Our ref: WA/2014/117209/01-L01
Your ref: 14/00241/F
Date: 26 March 2014

Demolition of existing dwelling and erection of 4 bed one and a half storey dwelling.

Dairy Cottage Main Street Wendlebury Bicester OX25 2PR

BLOCK PLAN and LOCATION PLAN As Proposed
1:100 & 1:250 TPH December 2013
Original at A1 Drwg no. 13 / 141.05

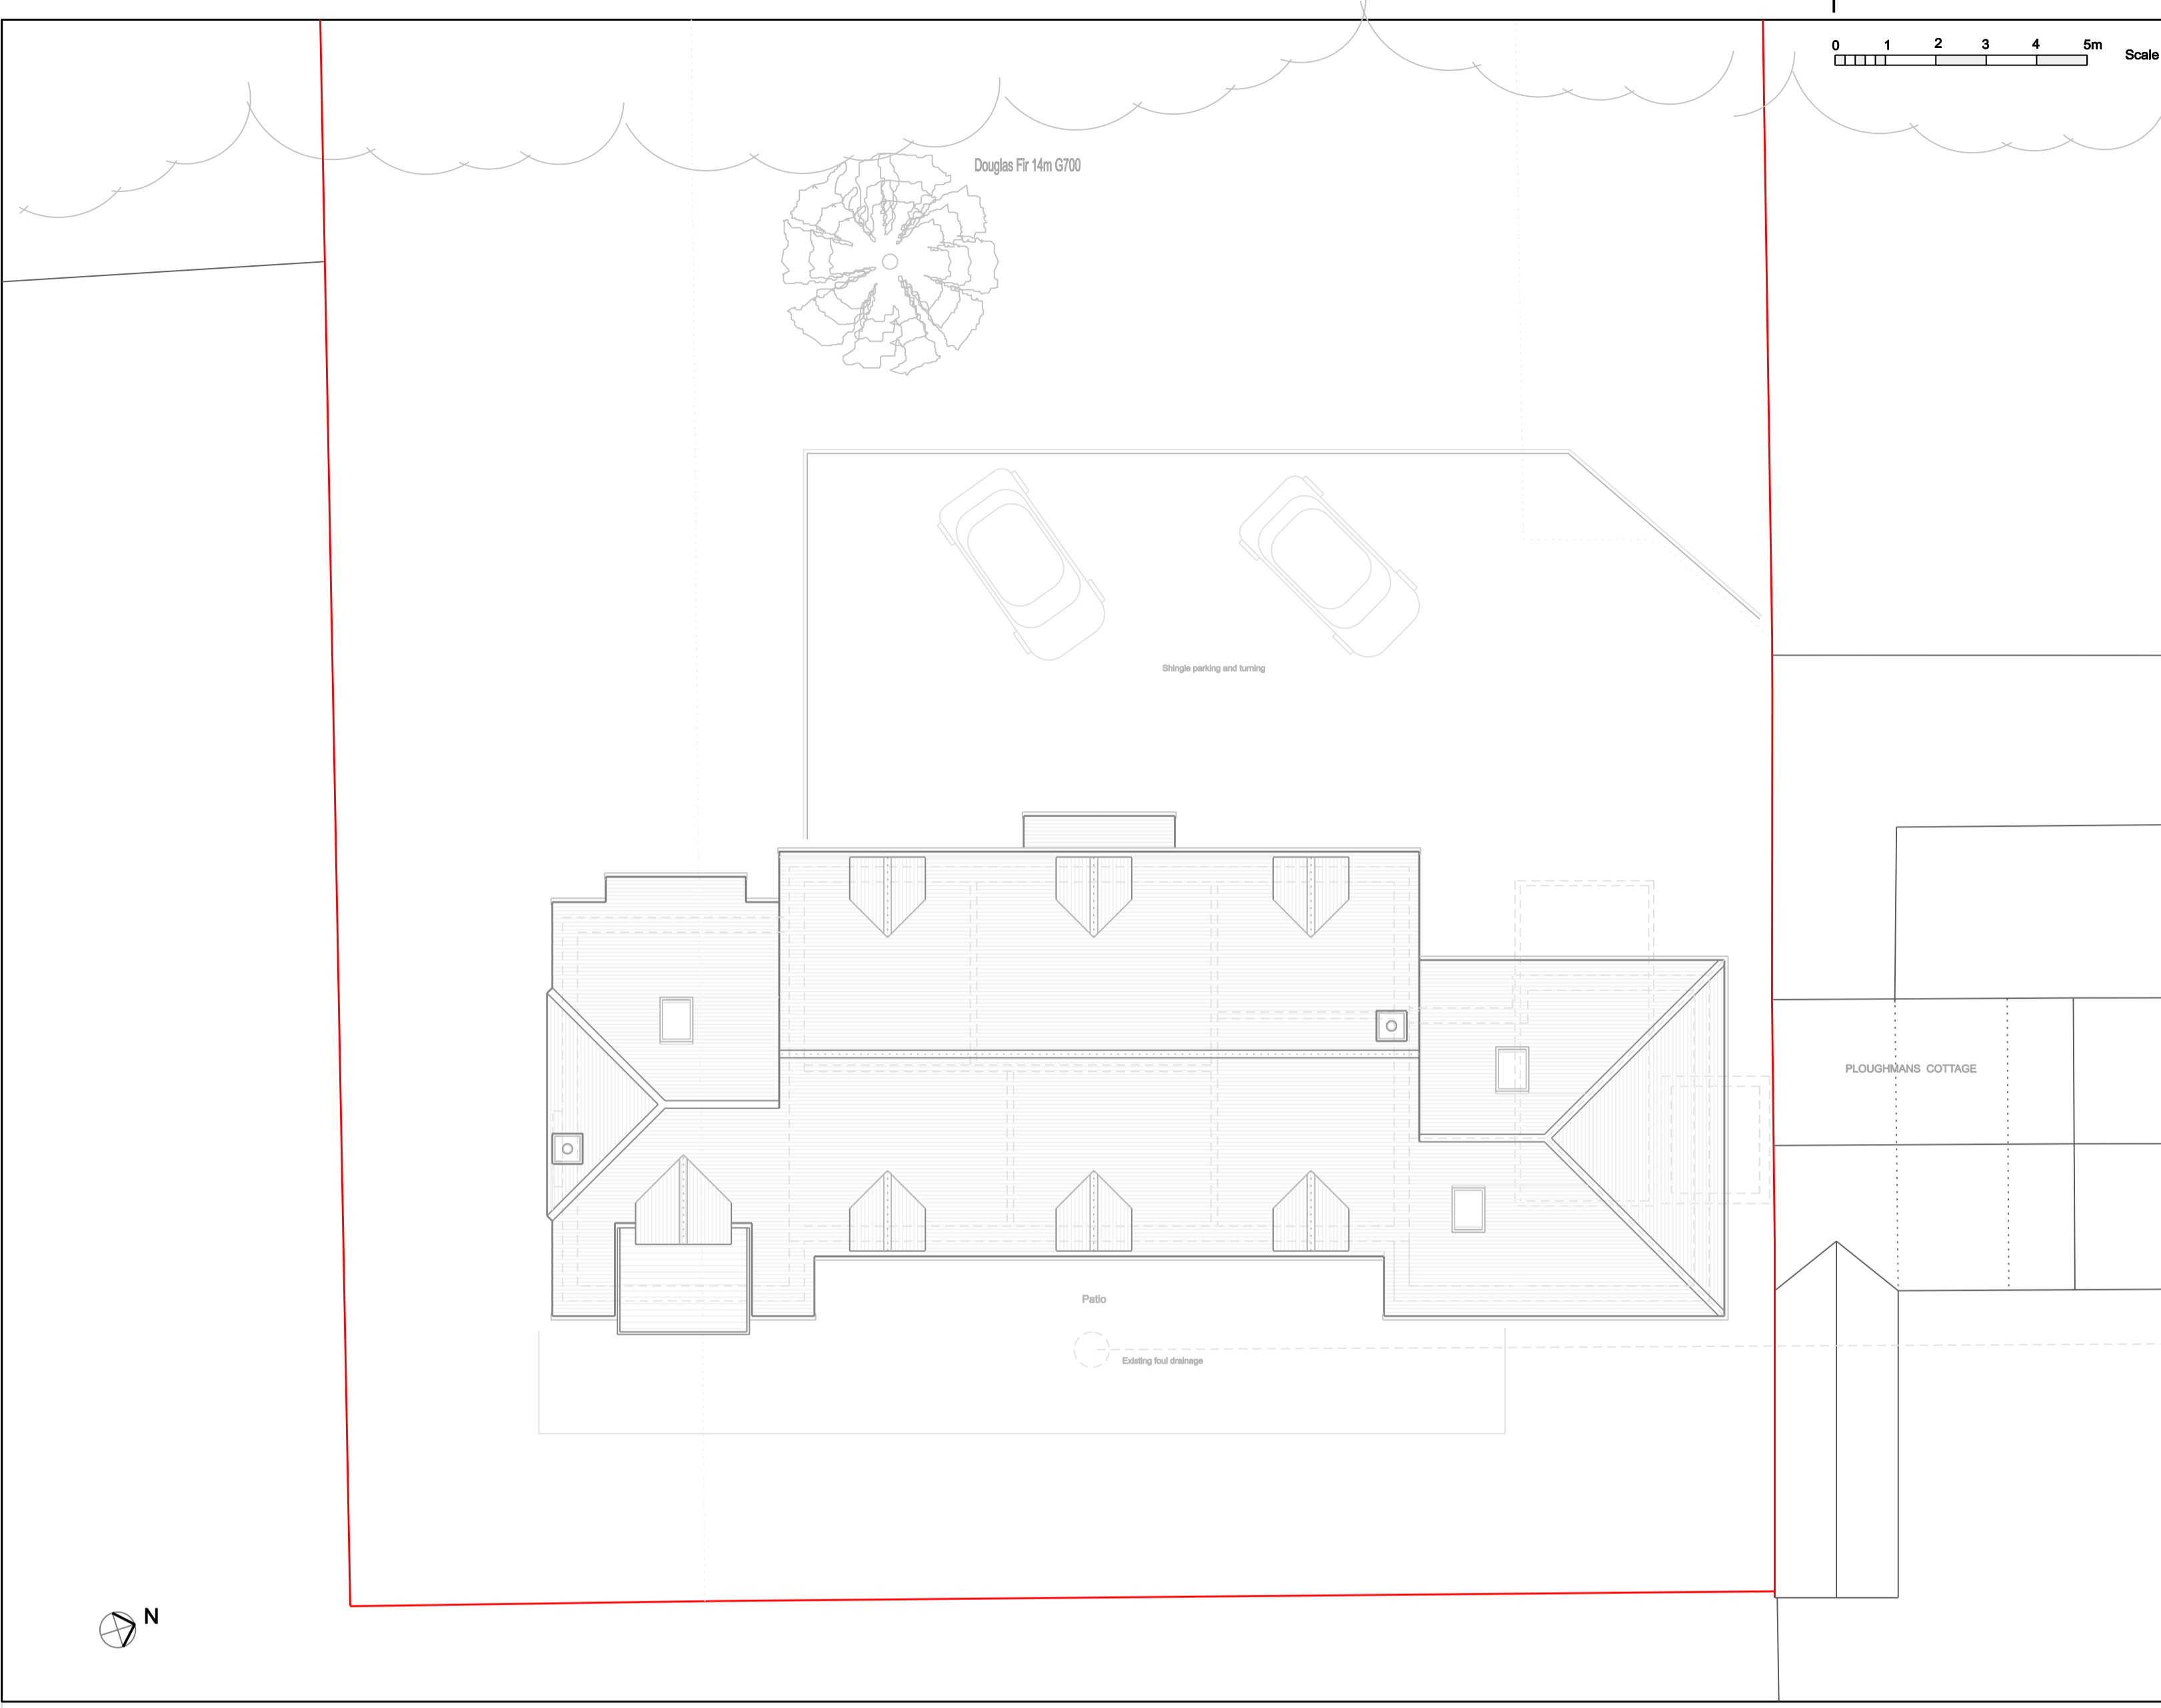
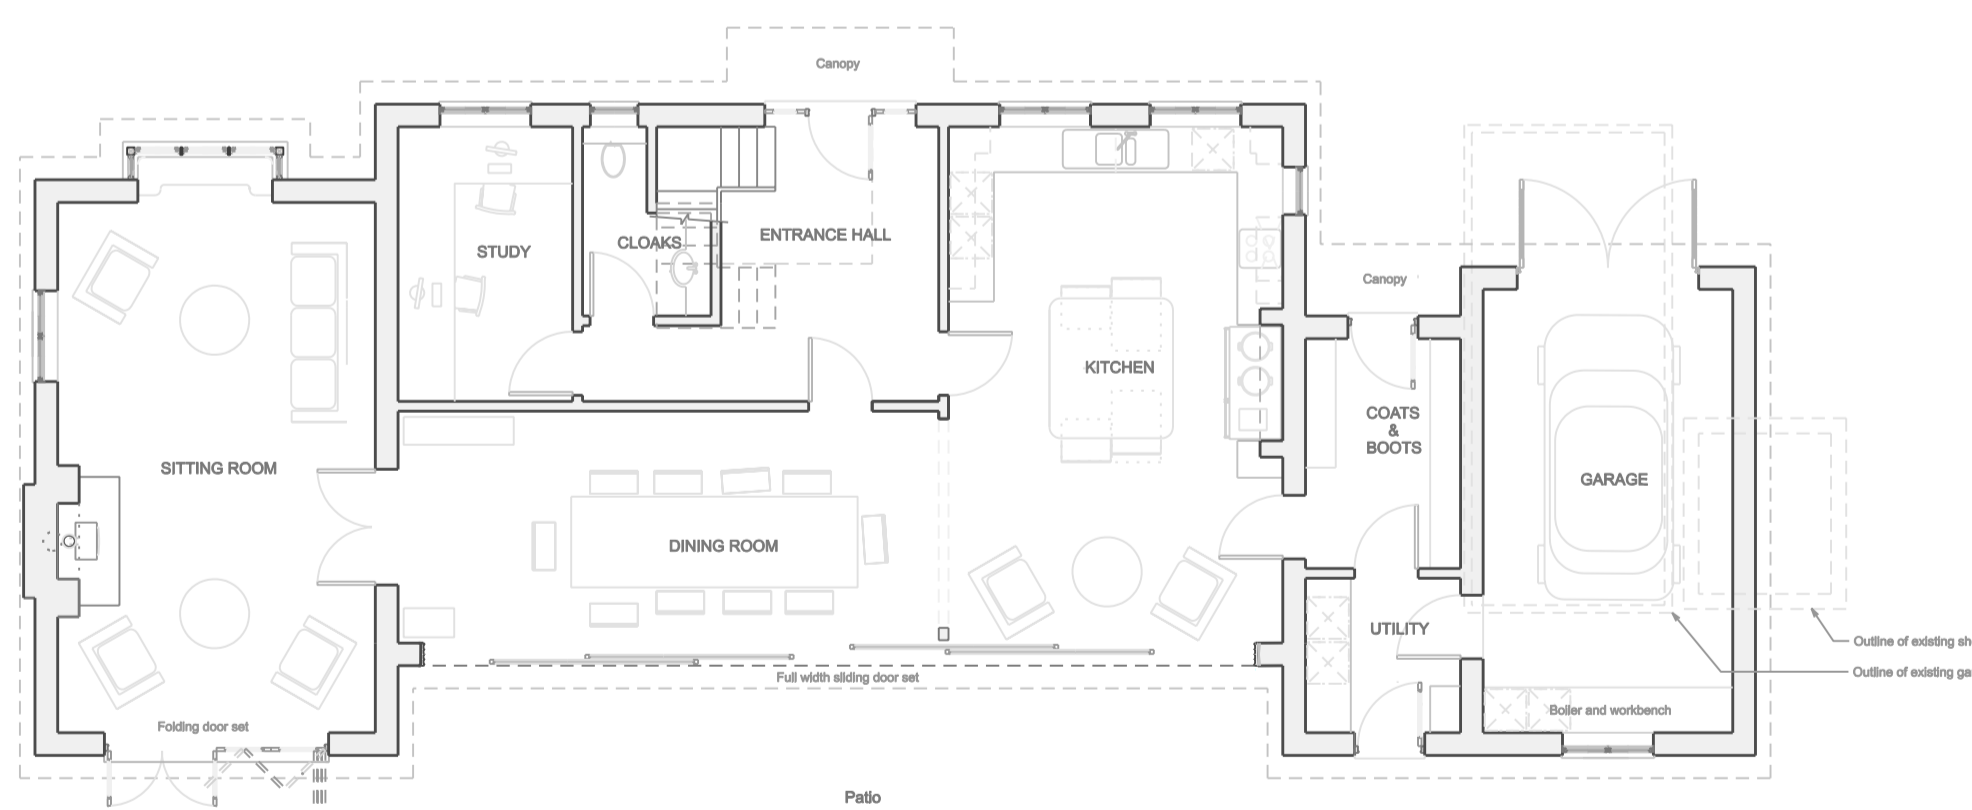
As the redline boundary of the site includes areas of Flood Zone 2 and 3 (adjacent to the Wendlebury Brook) the application should be accompanied by a Flood Risk Assessment (FRA) in strict accordance with the National Planning Policy Framework (NPPF). However, a review of the proposed plan indicates the proposed building lies well outside of these areas.

No development or land raising shall be undertaken in the areas of the site shown as Flood Zone 2 or 3 on the Environment Agency's Flood Map (Flooding for Rivers and the Sea).
